Project Name: * Hampstead Bypass

Subject: Request for Modification to Individual Section 404 and Section 401 Water Quality Certification for the proposed Hampstead Bypass in Pender County. State Project No. 40237.1.2, TIP No. R-3300B. Debit \$570.00 from WBS No. 40237.1.1

The purpose of this letter is to request modification of the Clean Water Act (CWA) Section 404 Individual Permit (IP) and Section 401 Water Quality Certification for R-3300B.

PROJECT REFERENCE NO. <b>R-3300B</b>	SHEET NO. <b>19</b>
ROADWAY DESIGN ENGINEER <b>Michael D. Lindsey</b> Professional Engineer License No. 025513	HYDRAULICS ENGINEER <b>Joshua G. Dalton</b> Professional Engineer License No. F-0672
11/22/2021	11/22/2021

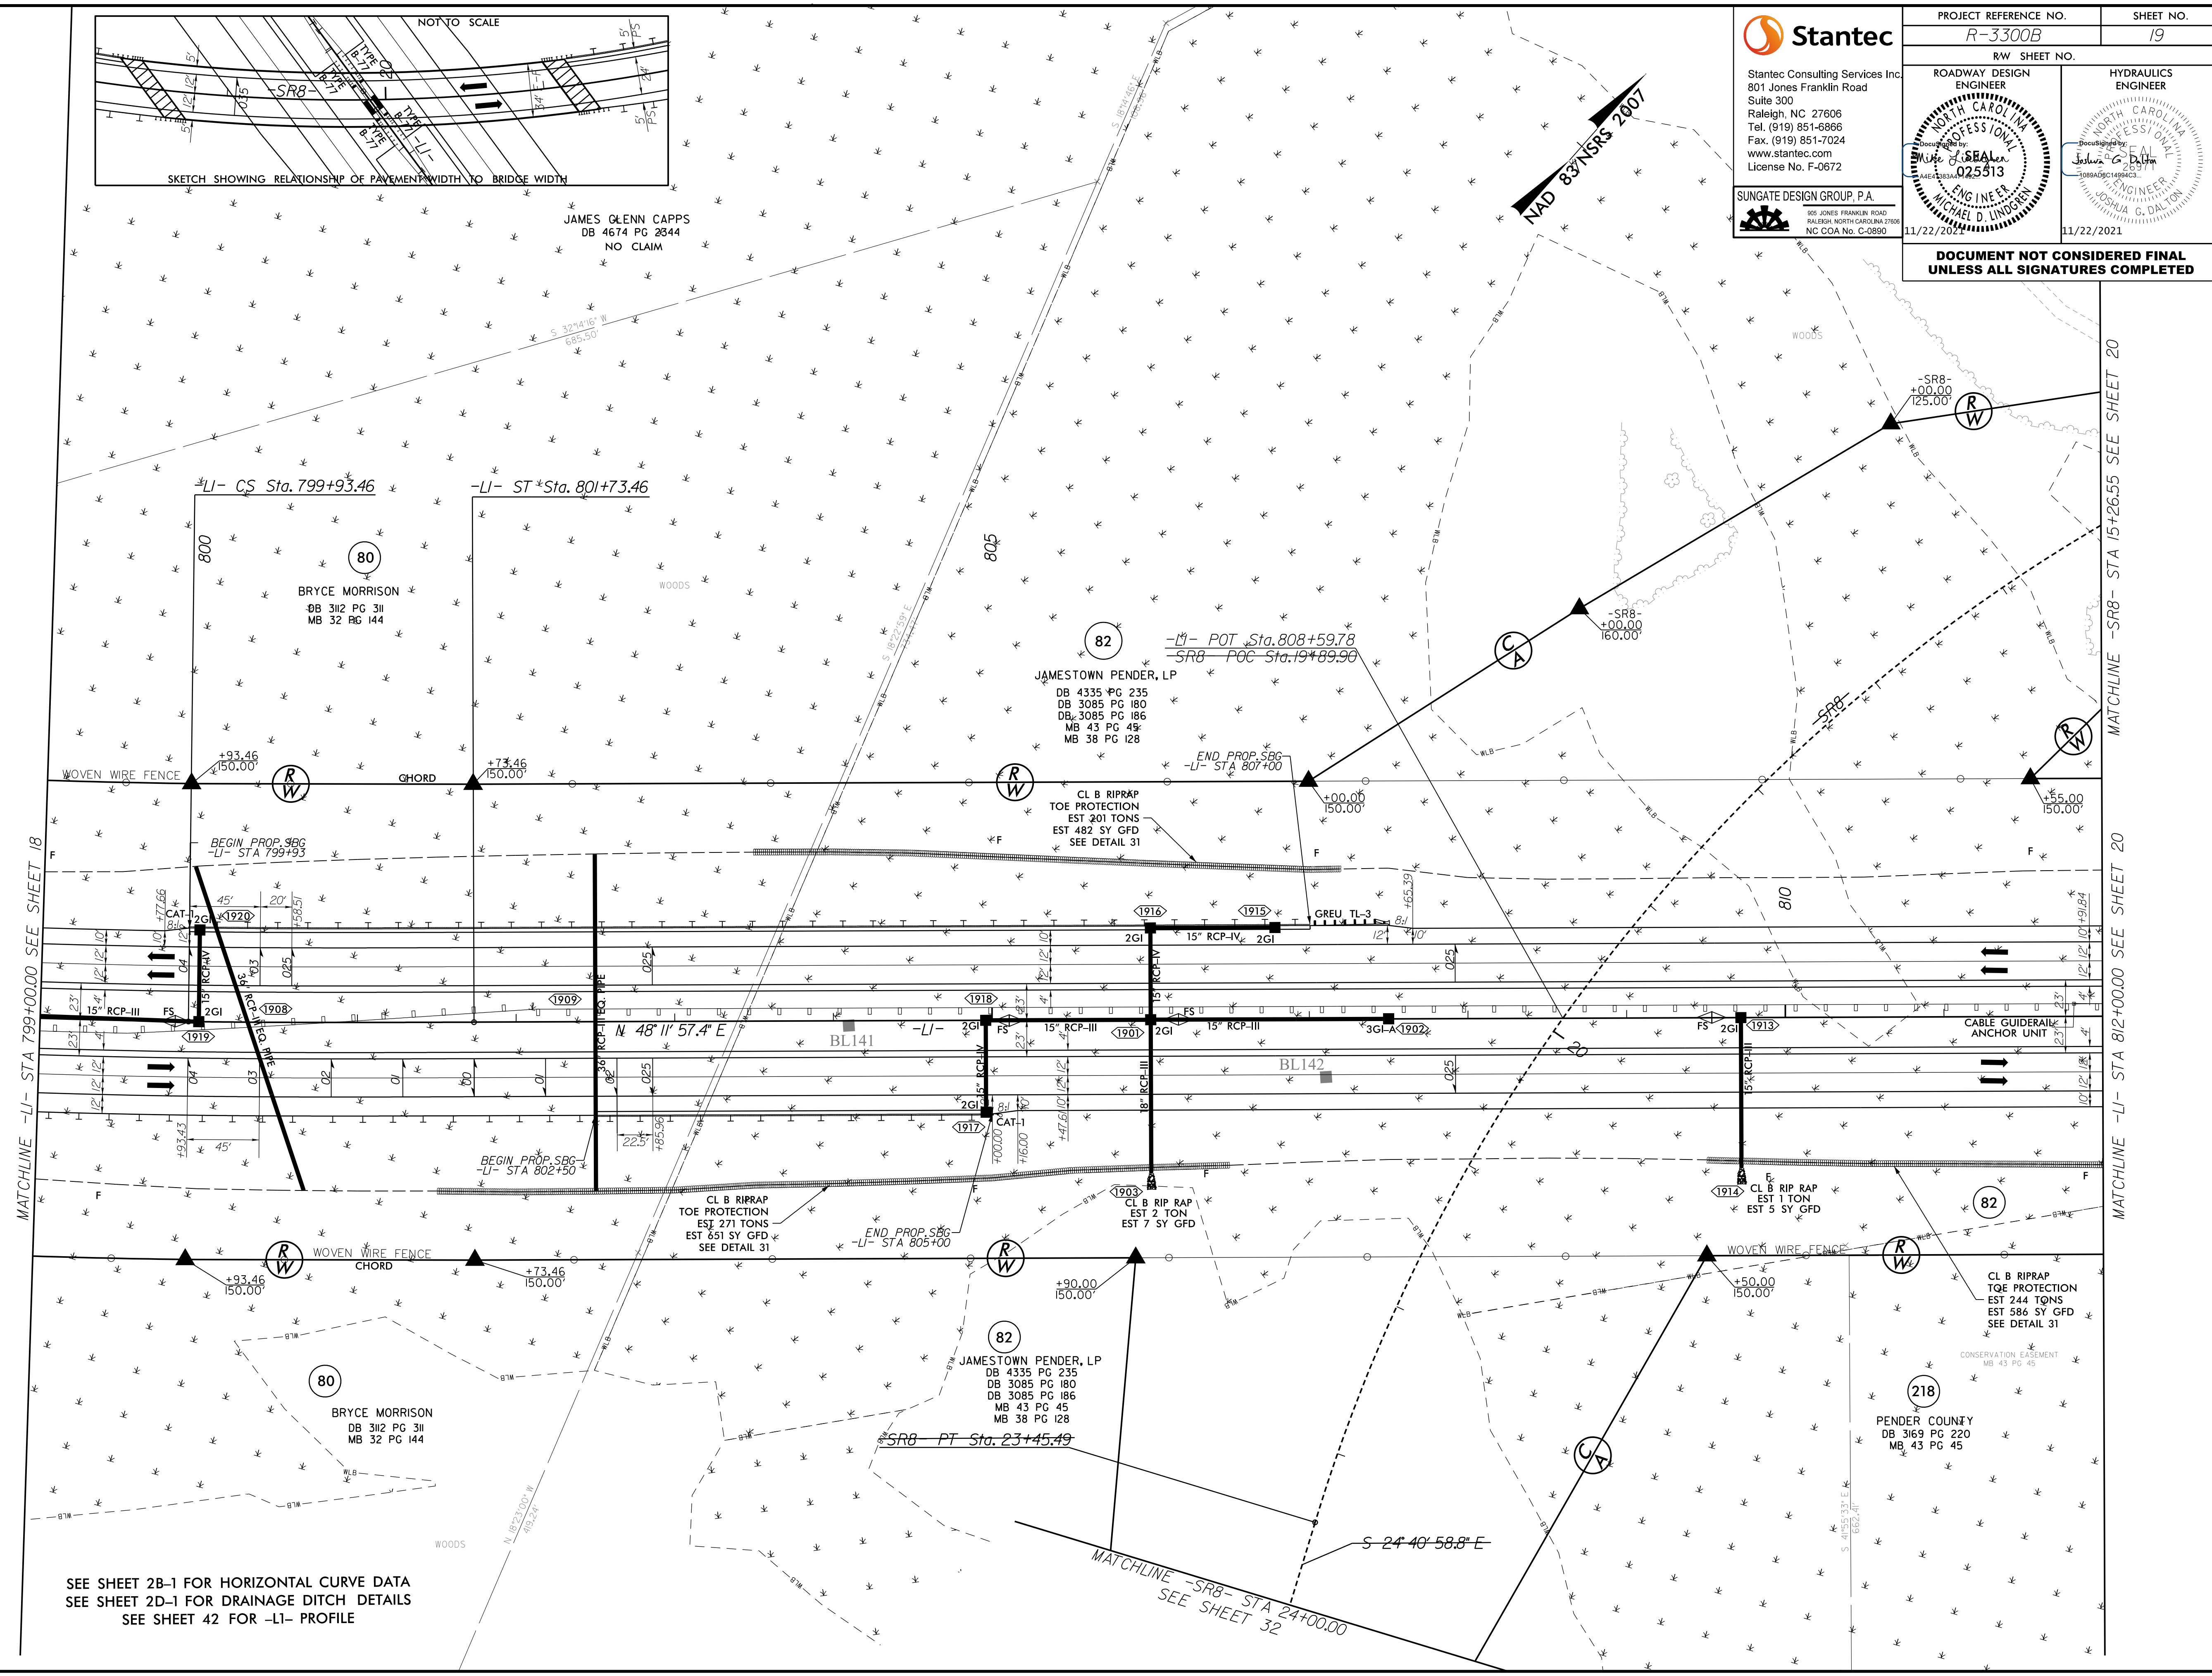
- Removal of Service Road (SR) 8 – The need for Service Road 8 (SR 8) and its associated bridge over proposed Hampstead Bypass were identified early in the project planning process since the project cut off access to a very large portion of the Jamestown Pender, LP property (right of way parcel 82 plan sheets 19 -23 & 32). However, following protracted negotiations with legal representatives of this Map Act property, a determination was made to purchase the entire property which negated the need for SR8. This change has decreased permanent non-riparian wetland impacts by 2.02 acres (1.947 ac of permanent fill and 0.055 ac of mechanized clearing).
